Project # 1006606

Project Name: Video Adn.

M E M O

Re: Project #1006606, SDP Building Permit – Burger King on Eubank SE

Plat of
 Tracts B1-B-1 and B1-B-2
Video Addition
 Albuquerque, Bernalillo County, New Mexico
 June 2011

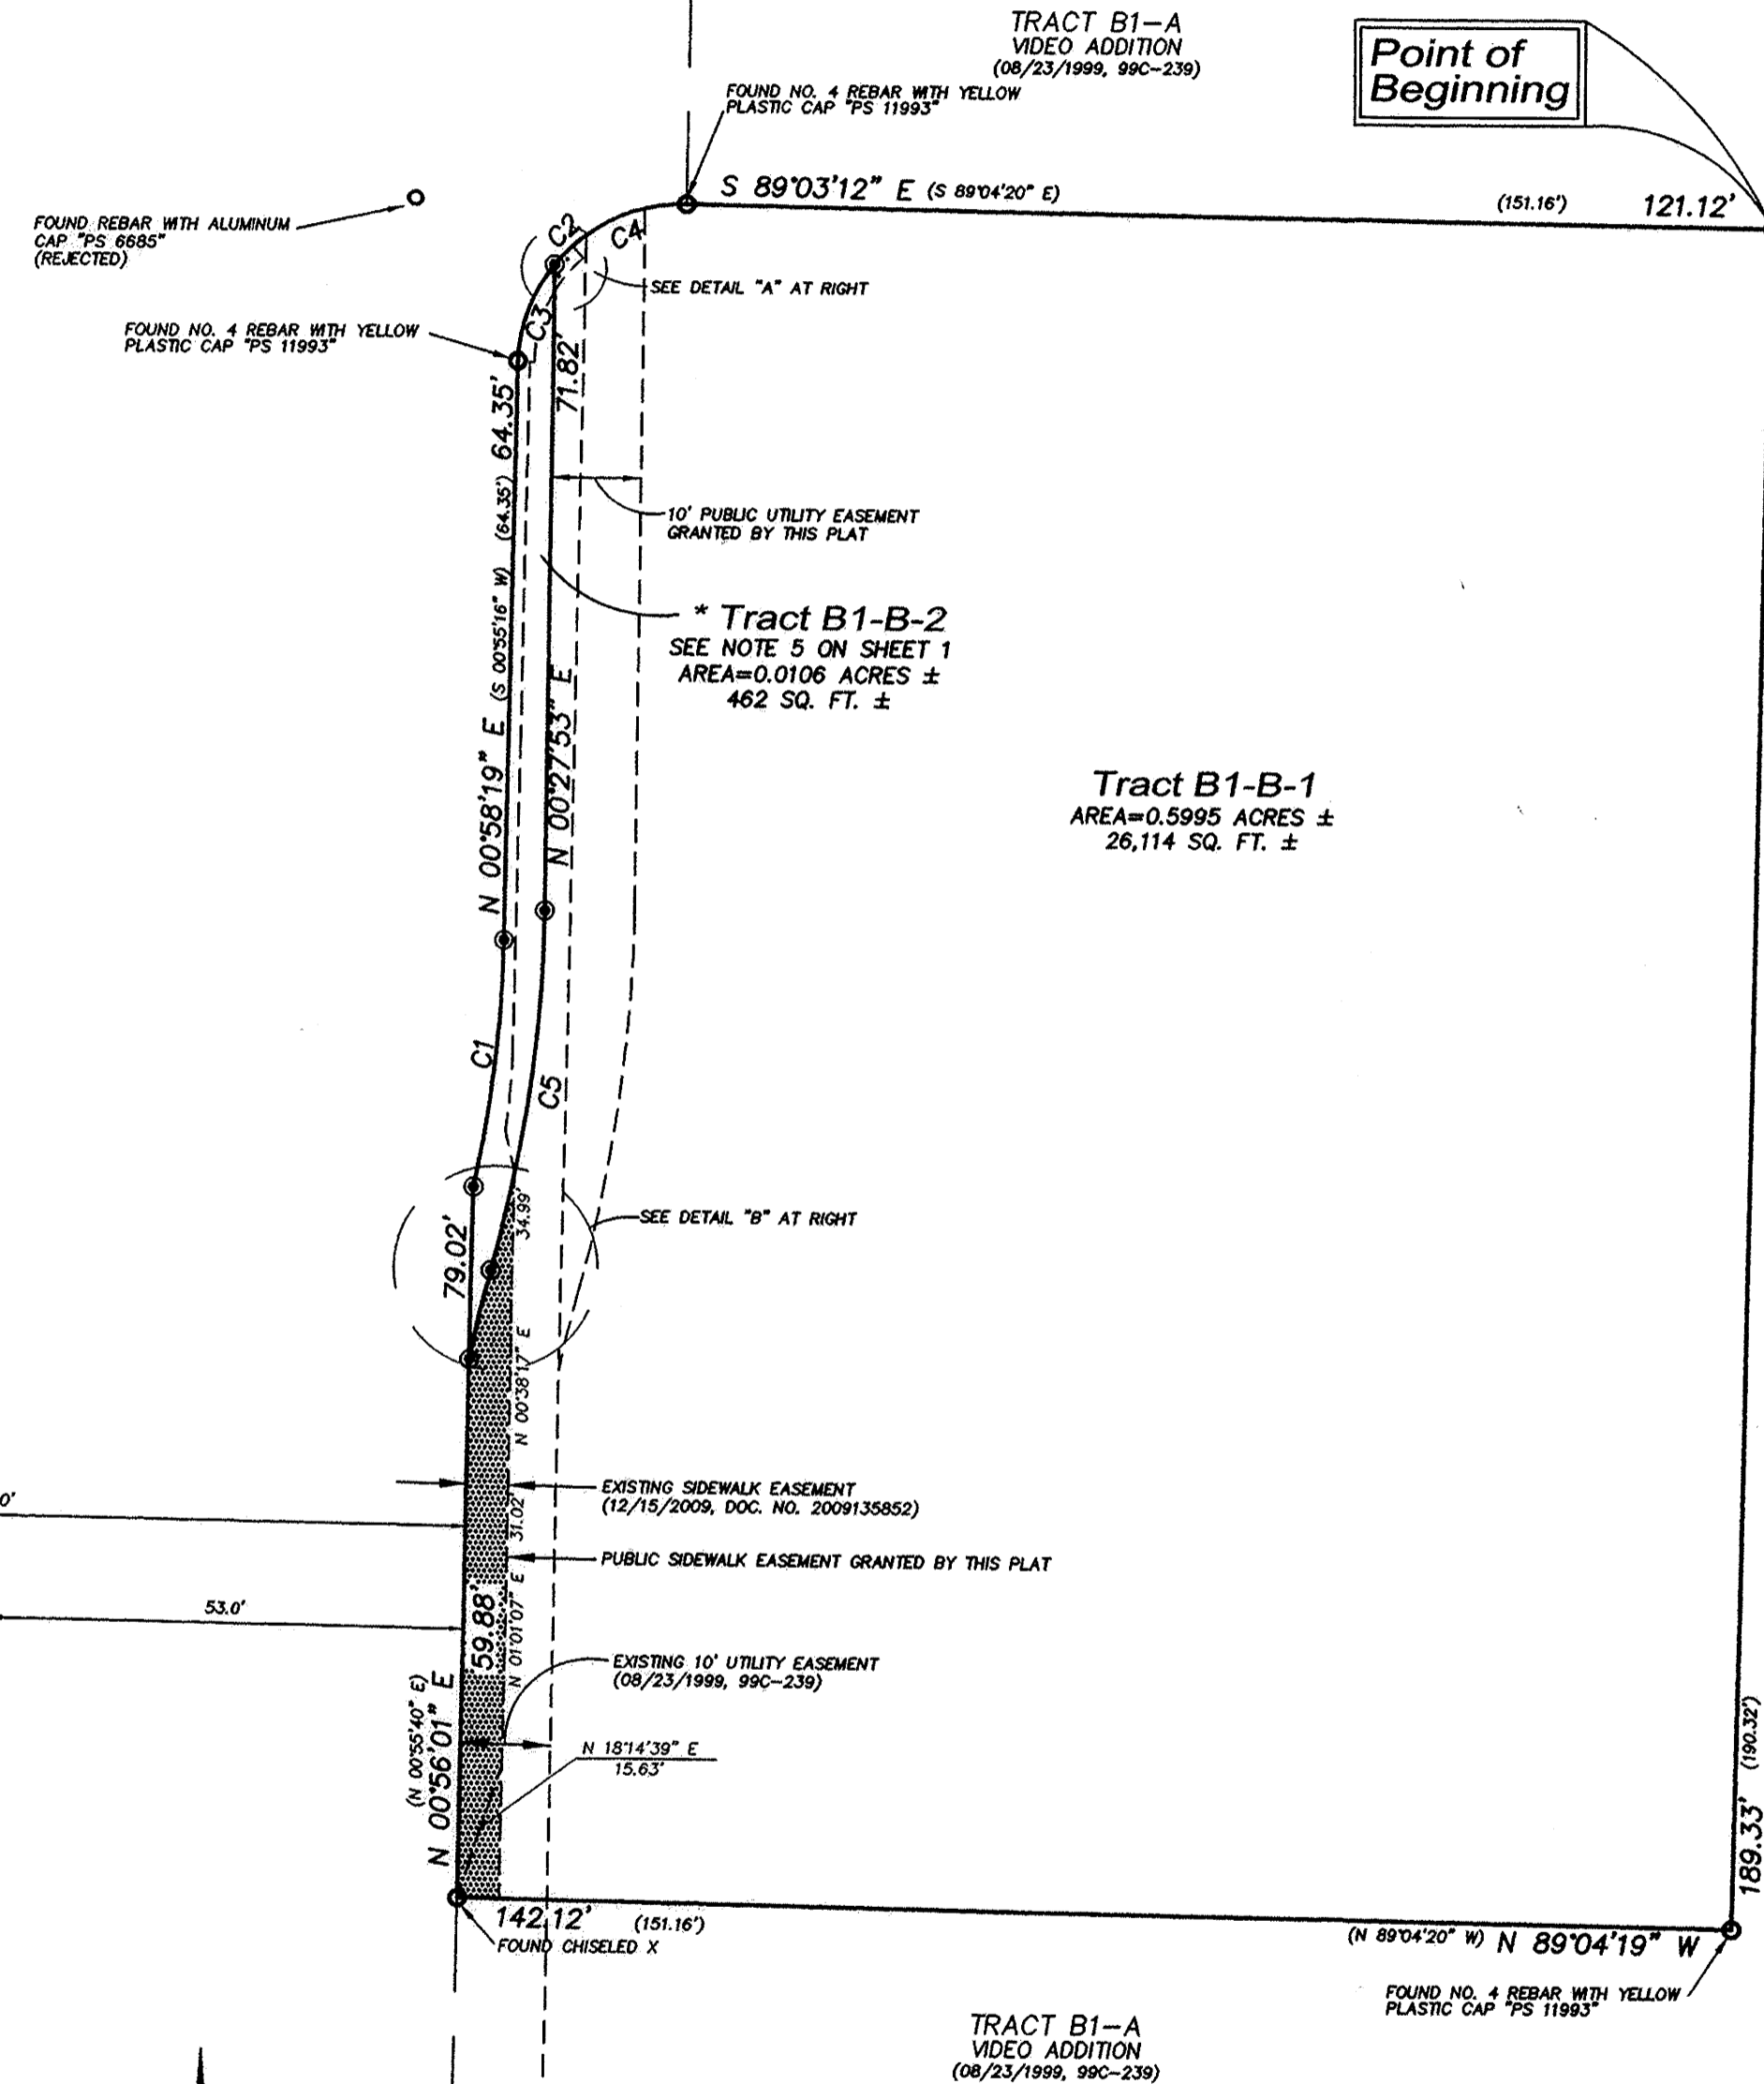
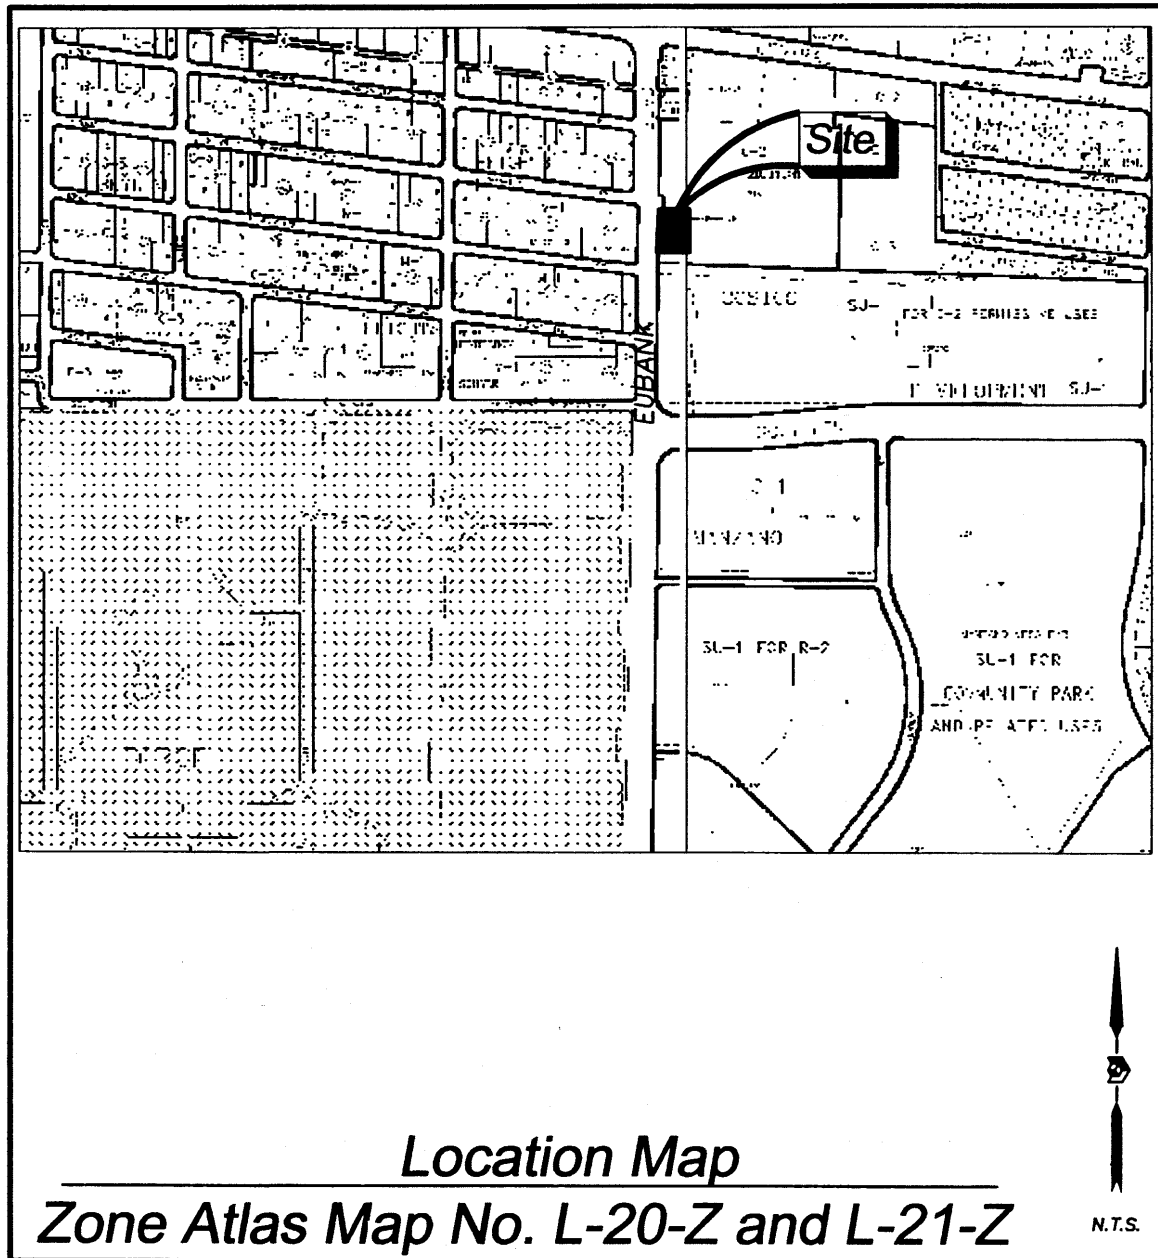
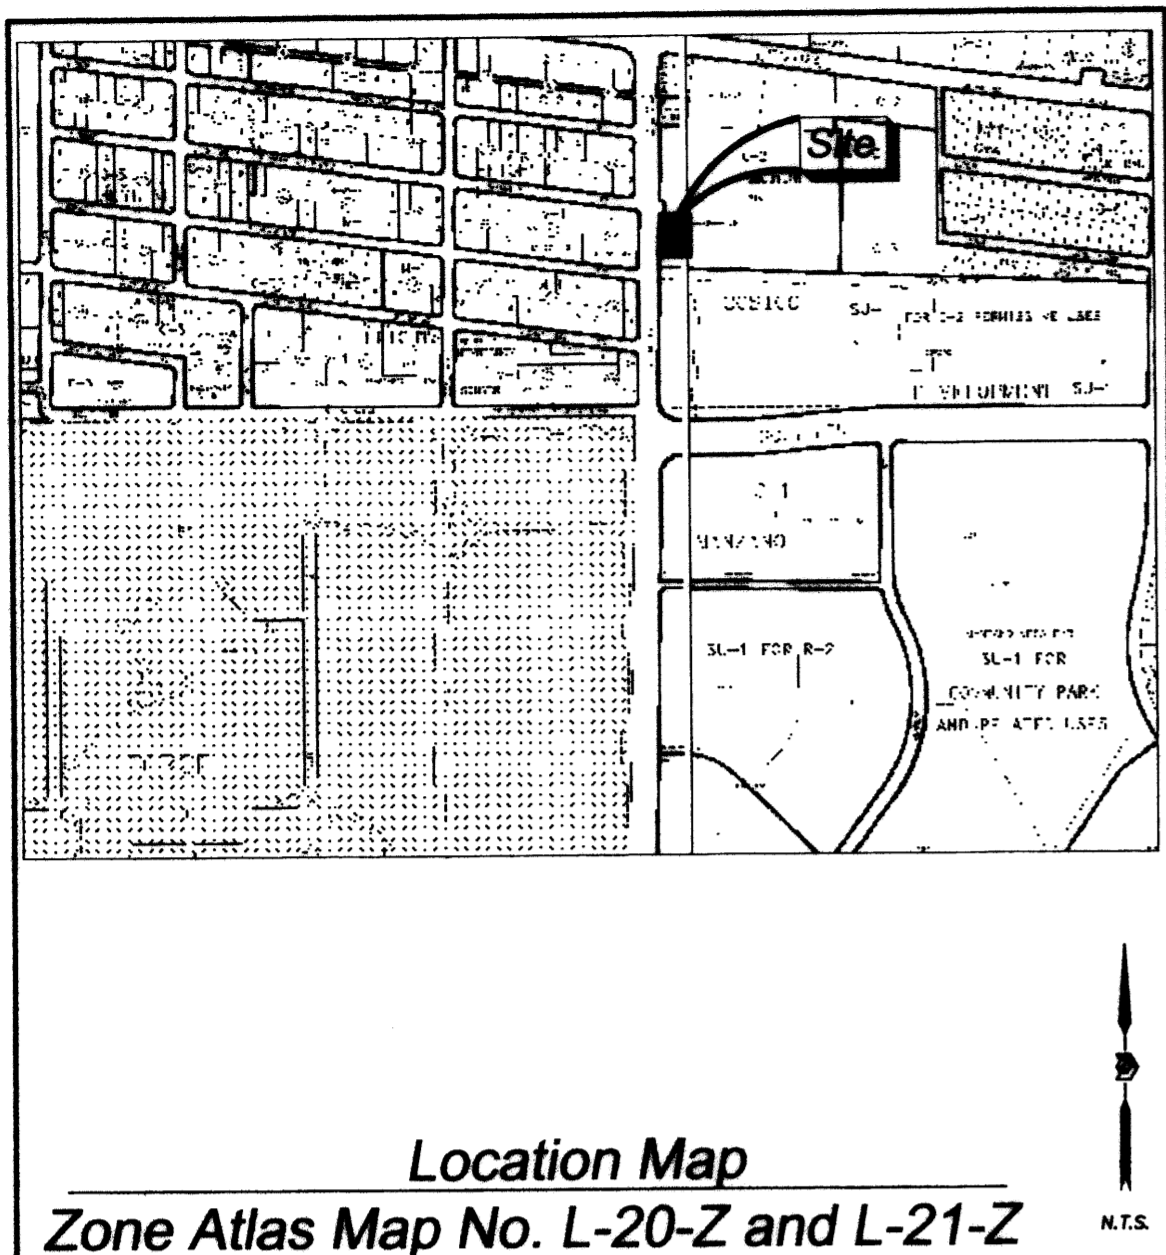
PLANNING (Last to sign): dxp
- label streets / Vicinity Map

The quality of the vicinity map should be improved so that Central and Southern Avenues are legible. Else, Hydrology has no objection.

PROJECT TITLE
200 EUBANK BLVD.
 S.W.C. OF EUBANK AND CENTRAL ALBUQUERQUE, NEW MEXICO

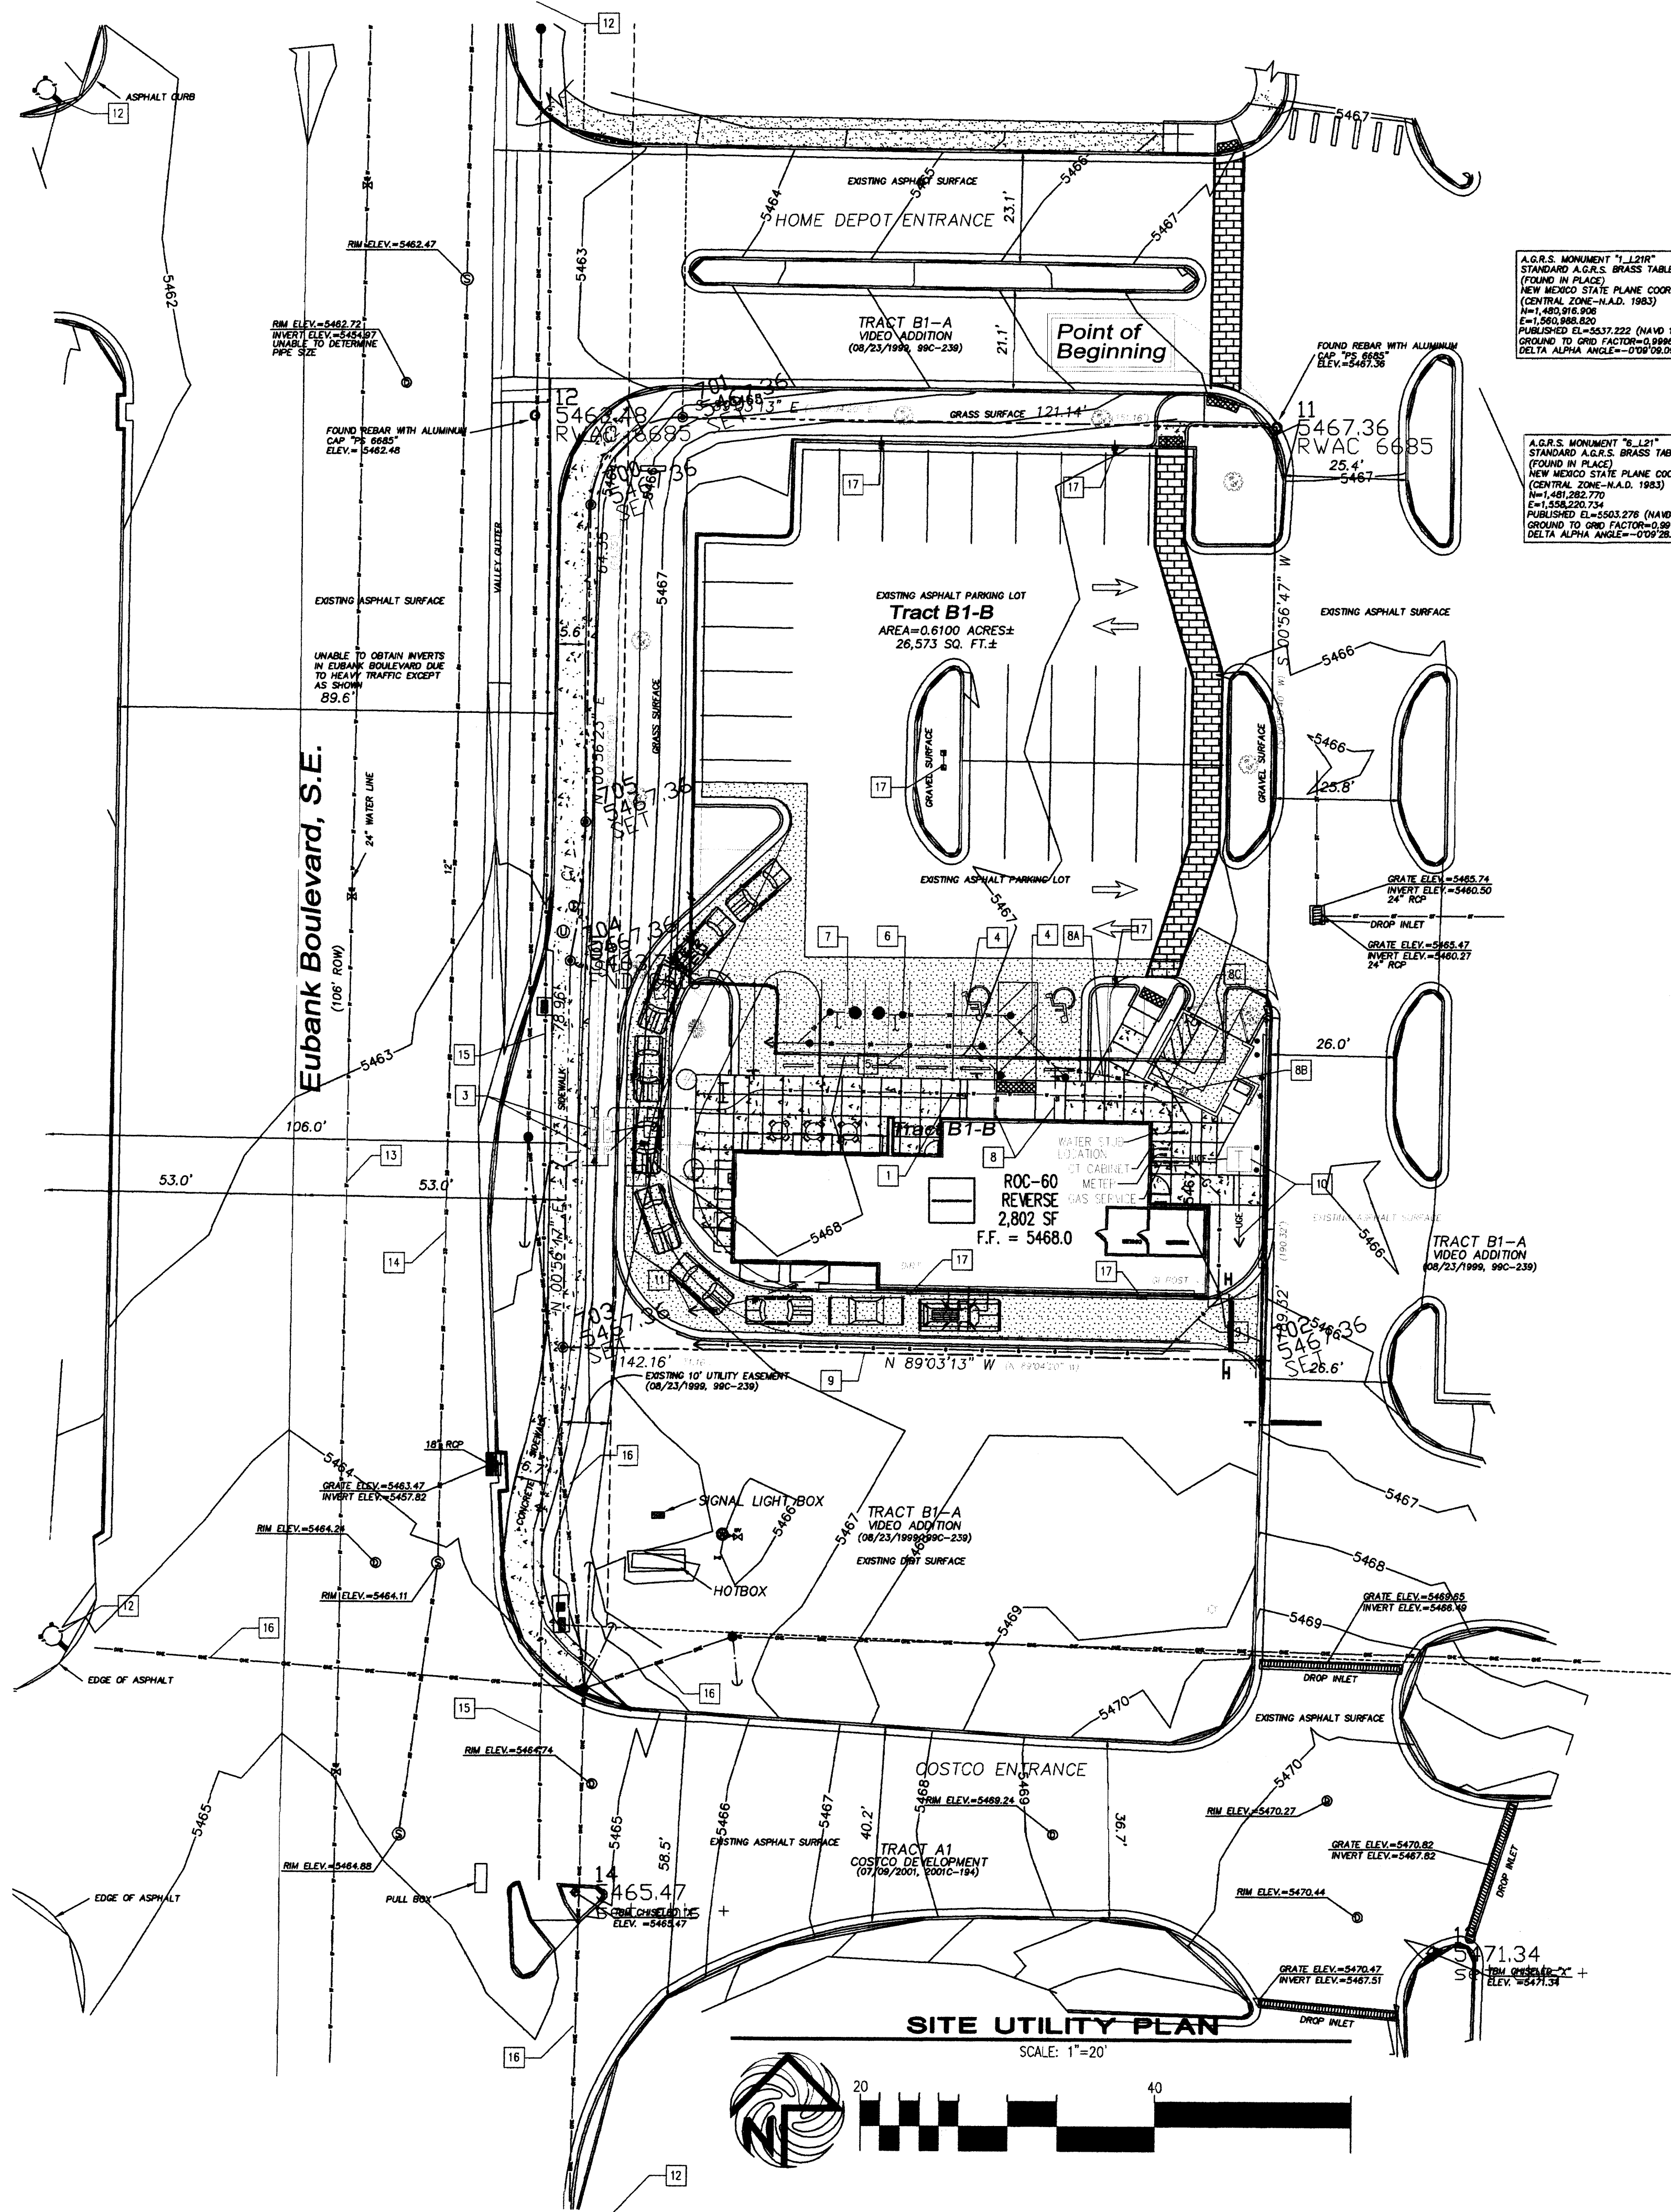
- ✓ Provide a detail for the wheelchair ramps located within the site. Define the maximum slope (1:12).
- ✓ Clarify the location of the proposed public roadway easement. A recorded copy of this easement must be provided prior to sign off by ~~Transportation Development~~.
- ✓ Provide a build note for the proposed ramps within City right of way. Refer to City of Albuquerque Standard Number 2441.

- #3 - Staff planner delegates review to the DRB. However, note that the two-way directional arrows on the site drives should be transposed.
- #5 – The wall should be 4' high and have a stucco finish, i.e. the same as the refuse enclosure (detail 11 on C7) to match the building.

- #6 – A slight increase in the number of parking spaces is shown (33 instead of 30). The staff planner requests that one space be eliminated in front of the building to more safely accommodate the pedestrian walkway, bicycle rack and motorcycle spaces, along with the drive-thru lane and associated signage and screening. Between 30 and 32 spaces would be acceptable.

- #10 – All the notes, including from C3, should be grouped under one heading on the site plan (C2).
- #11.a.i – Add a note that the Austrian pines shall branch low to screen the drive-thru lane.
